LEAD LOCAL FLOOD AUTHORITY, OXFORDSHIRE COUNTY COUNCIL PROOF OF EVIDENCE

Proof of Evidence to the Planning Inspectorate on behalf of the Lead Local Flood Authority (LLFA) concerning the planning appeal Appeal by Great Lakes UK Limited against Cherwell District Council's refusal to grant planning permission for the Redevelopment of part of golf course to provide new leisure resort (sui generis) incorporating waterpark, family entertainment centre, hotel, conferencing facilities and restaurants with associated access, parking and landscaping at Land to the east of M40 and south of A4095 Chesterton Bicester Oxon

PINS reference: APP/C3105/W/20/3259189

Dealing with matters relating to FLOOD RISK & SUSTAINABLE DRAINAGE (Refusal Reason 5)

BGA AKSW XX XX SH C 9201 - P05

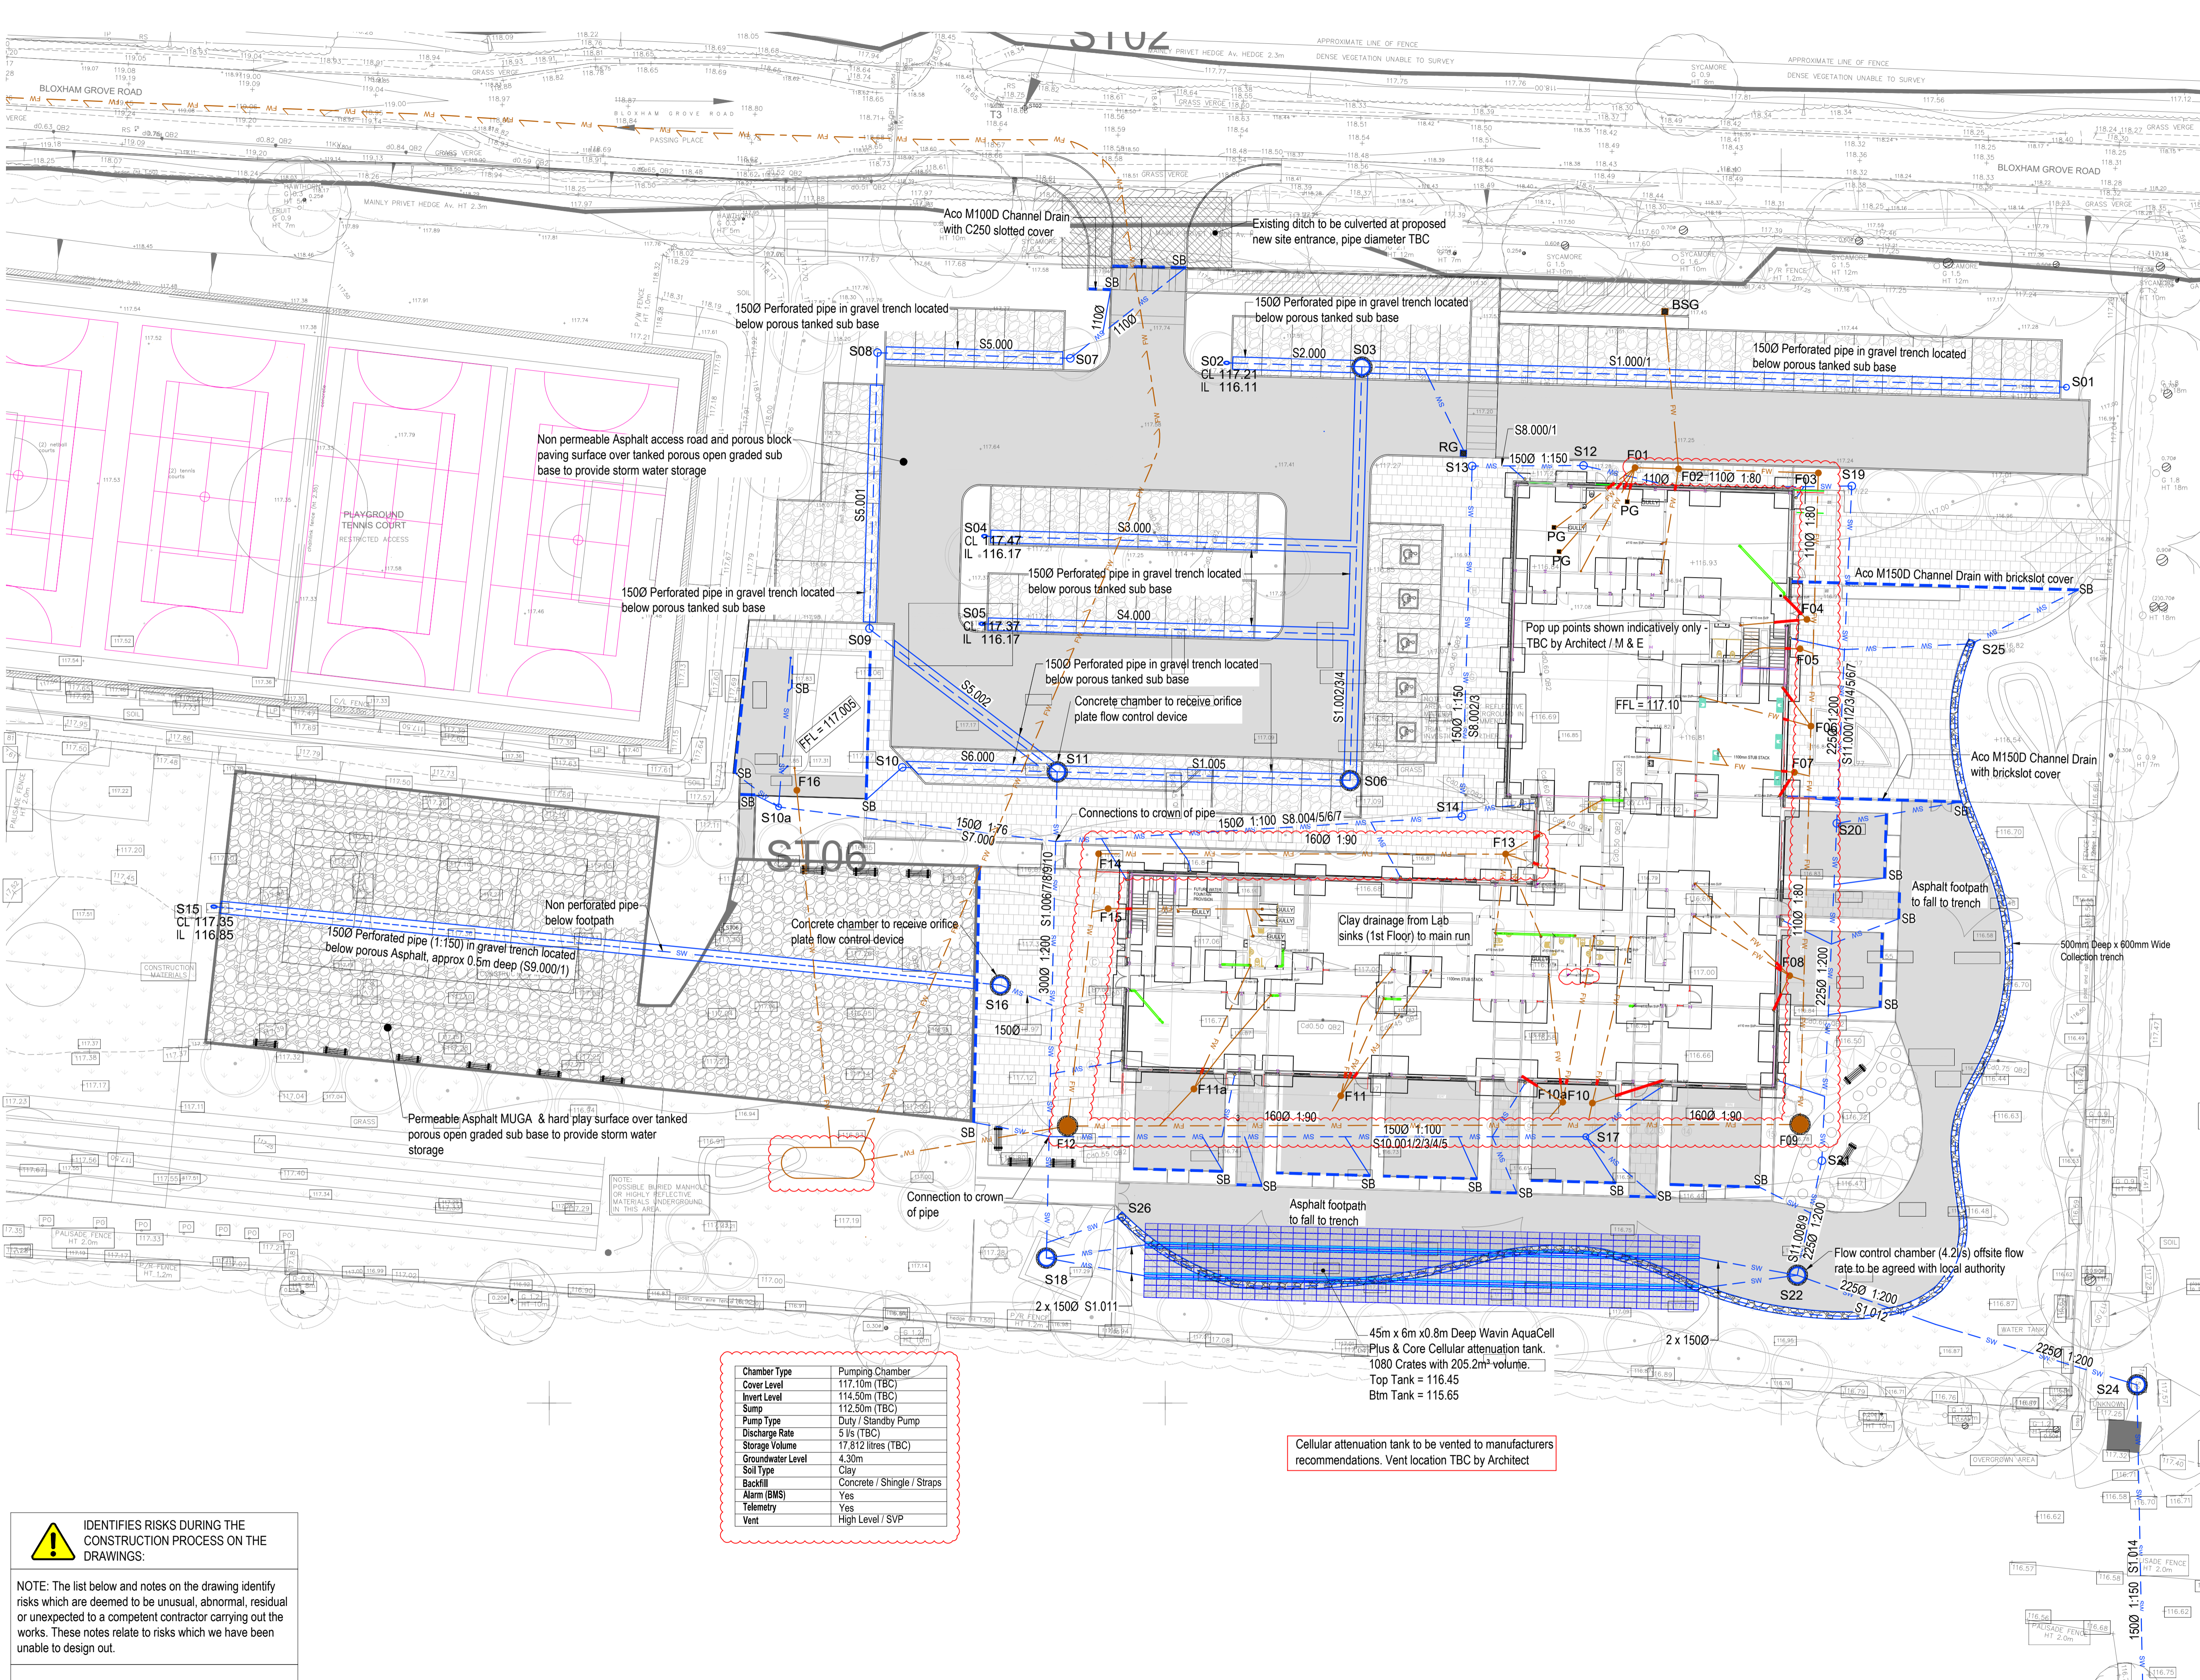
The drainage strategy failed to take account of advice from the lead local flood authority, does not have appropriate proposed minimum operational standards and does not provide biodiversity benefit compared to the existing drainage features on the site that are to be removed. It is therefore not in line with Local Plan Policies ESD6 and ESD7 and also Paragraphs 163 and 165 of the NPPF.
